# City of Albuquerque Stormwater Construction Site Inspection Report

ESC File No.	M21E018_R	Project Name:	Raylee Homes at Juan Tabo Hills Estates		
NPDES Id. No.	NMR1002FM	Location:	Popejoy, Rodey, and Sunset		
12/28/2021	Owner	Deligated Authority			
Operator	SLG Holdings, and TJT Group, LTD.		Raylee Homes field super		
Contact name & title	Jeff Grady		Sal Chavez		
e-mail	<a href="mailto:jgrady@rayleehomes.com">jgrady@rayleehomes.com</a>				
Contact Phone #	505-975-7544		975-1505		
COA Inspector	James Hughes		Start/End Time:	11am	
Construction Phase:	Vertical				
Type of Inspection:	Regular	Storm Event	Past Storm Event >0.25"	311/Complaint	Follow Up
Weather at time of inspection?		Cloudy		Temperature: ~	39
Estimated date of last storm 0.25" or greater			10/1/2021

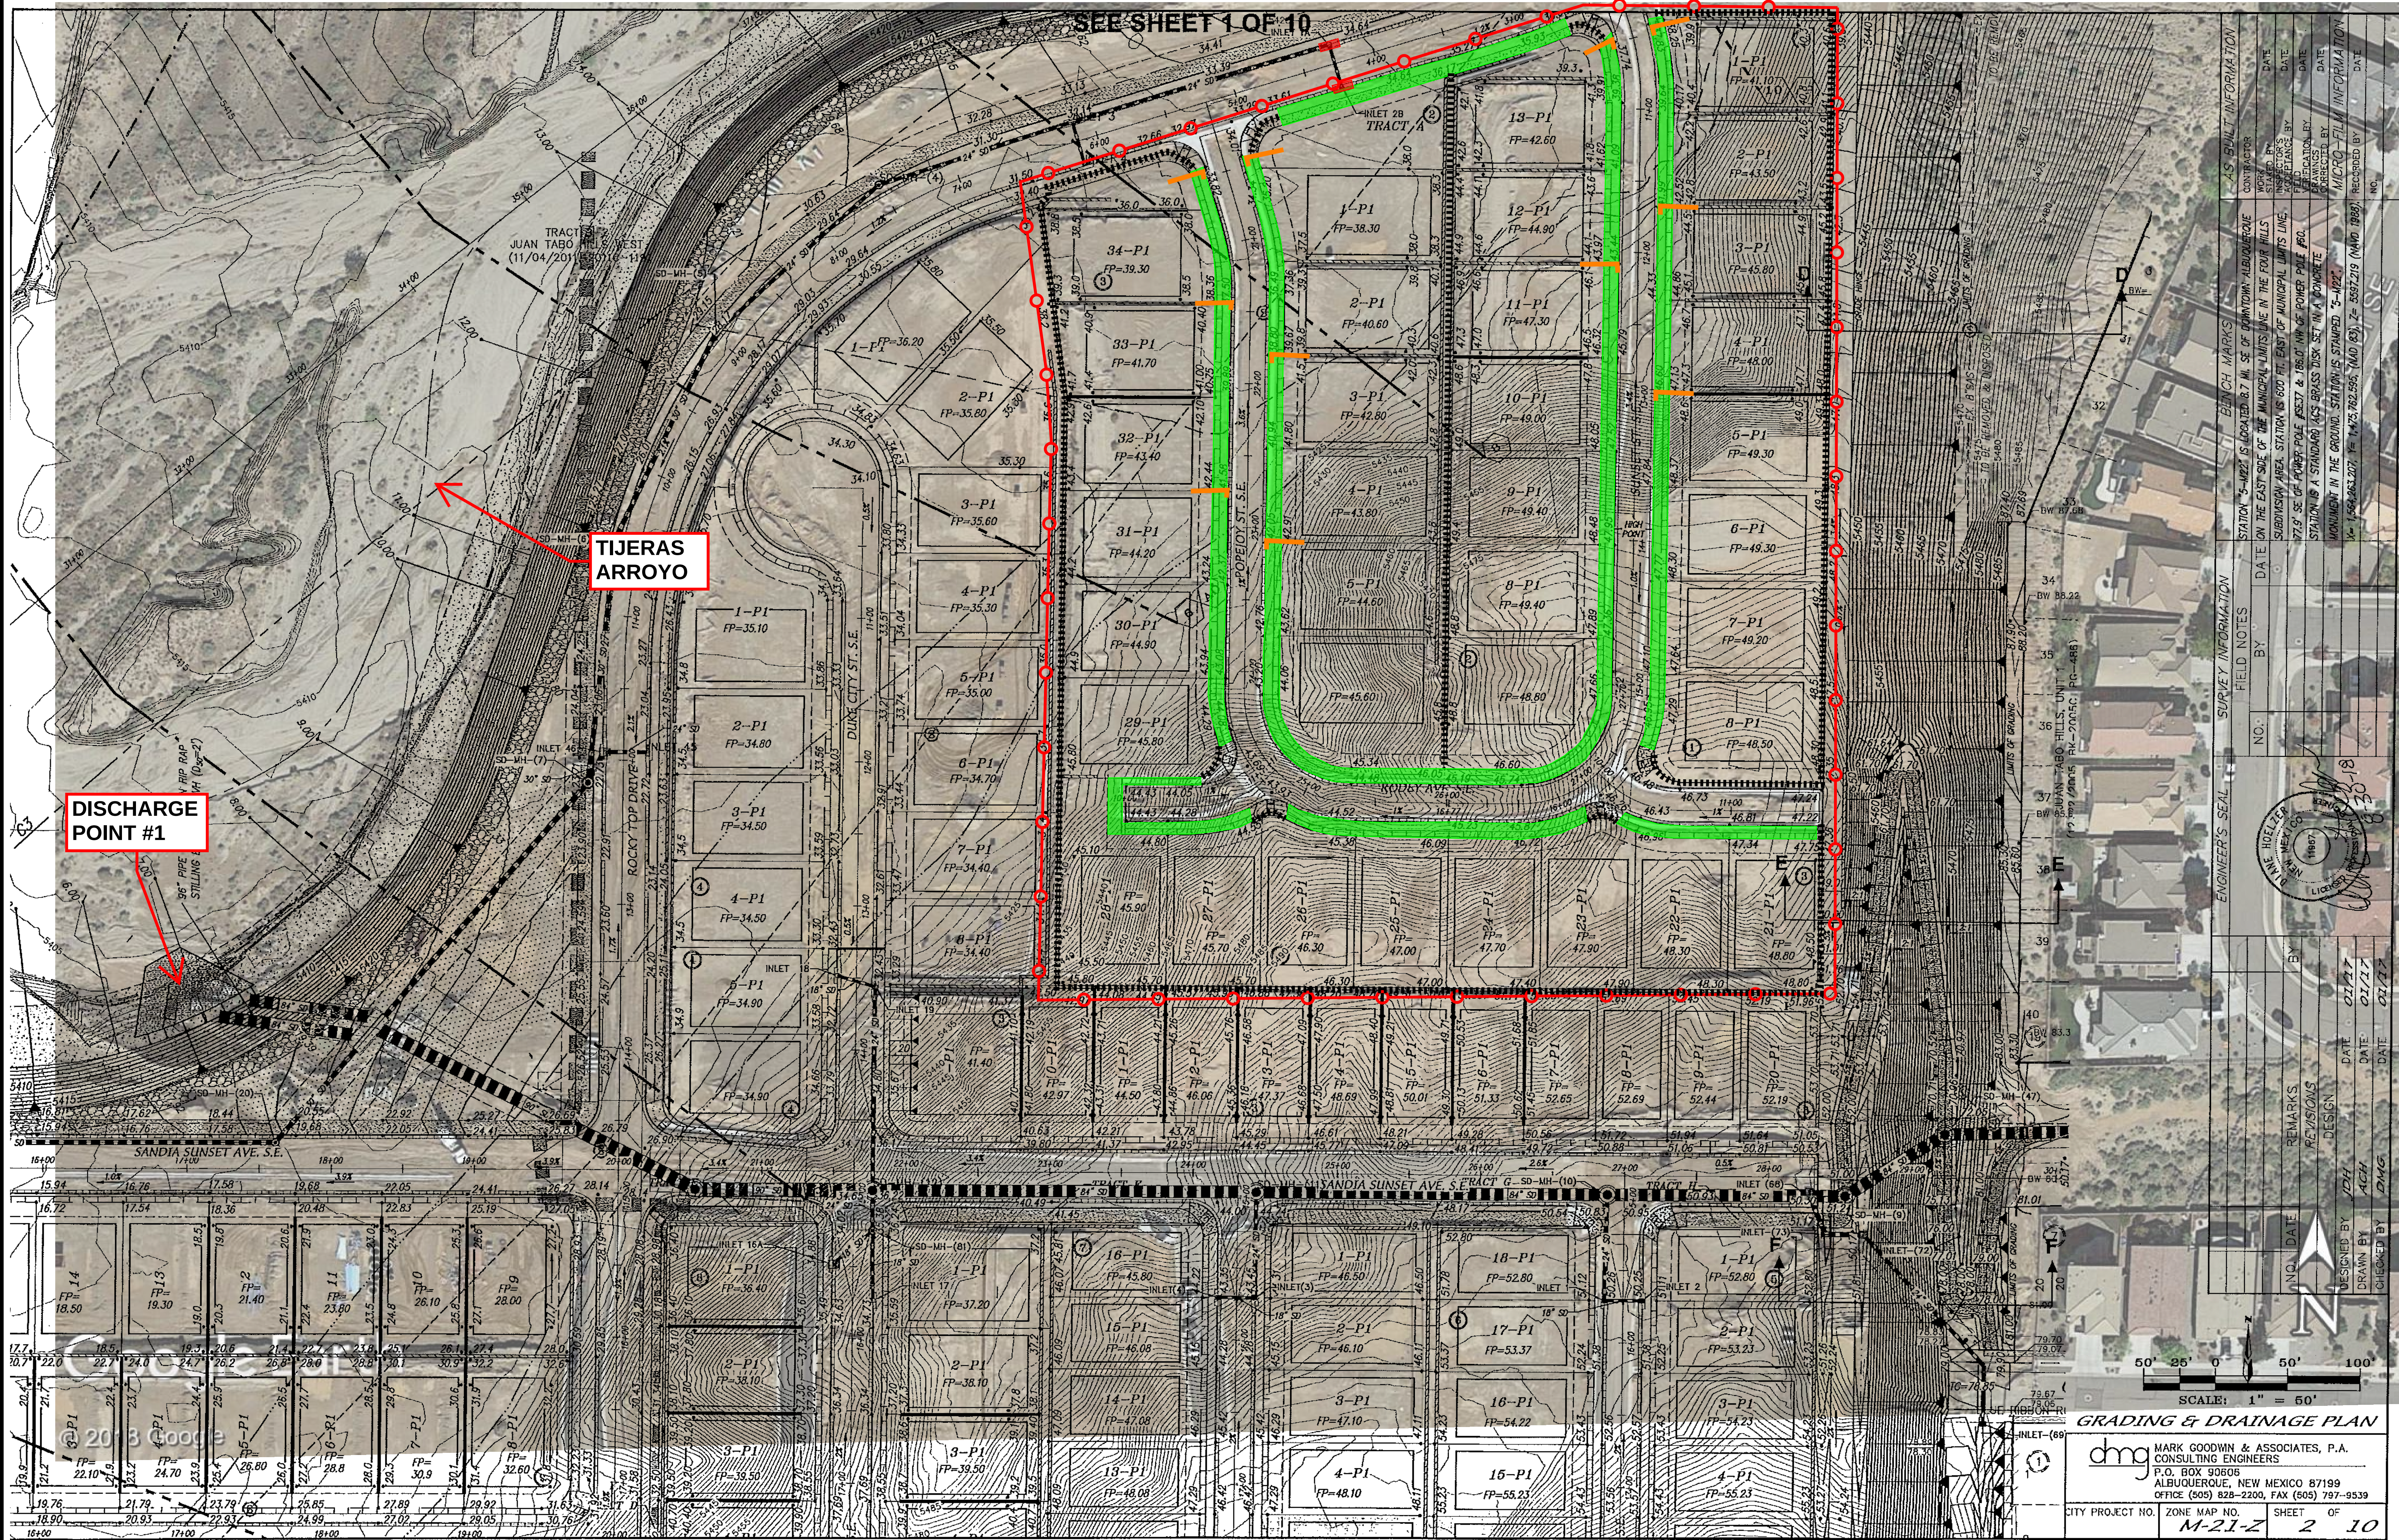
Item Number	Deficiency/ Corrective Action				
1	Washout on at least 3 lots. Remove and dispose of all existing washout. Place future Concrete, Stocco, and paint washwater in lined containers.				
2	Sediment in the street must be removed daily.				
3	Self-inspection reports not Signed by operator.				
4					
5

Notes:	Estimate 60 % built out. No washout containers.
SWPPP map signatures and deligation OK. SLG (aka Raylee) is both the contractor and owner and certified the SWPPP twice, once as each. Deligation to Sal Chavez (field Super) is in order.	
Field reports not signed.
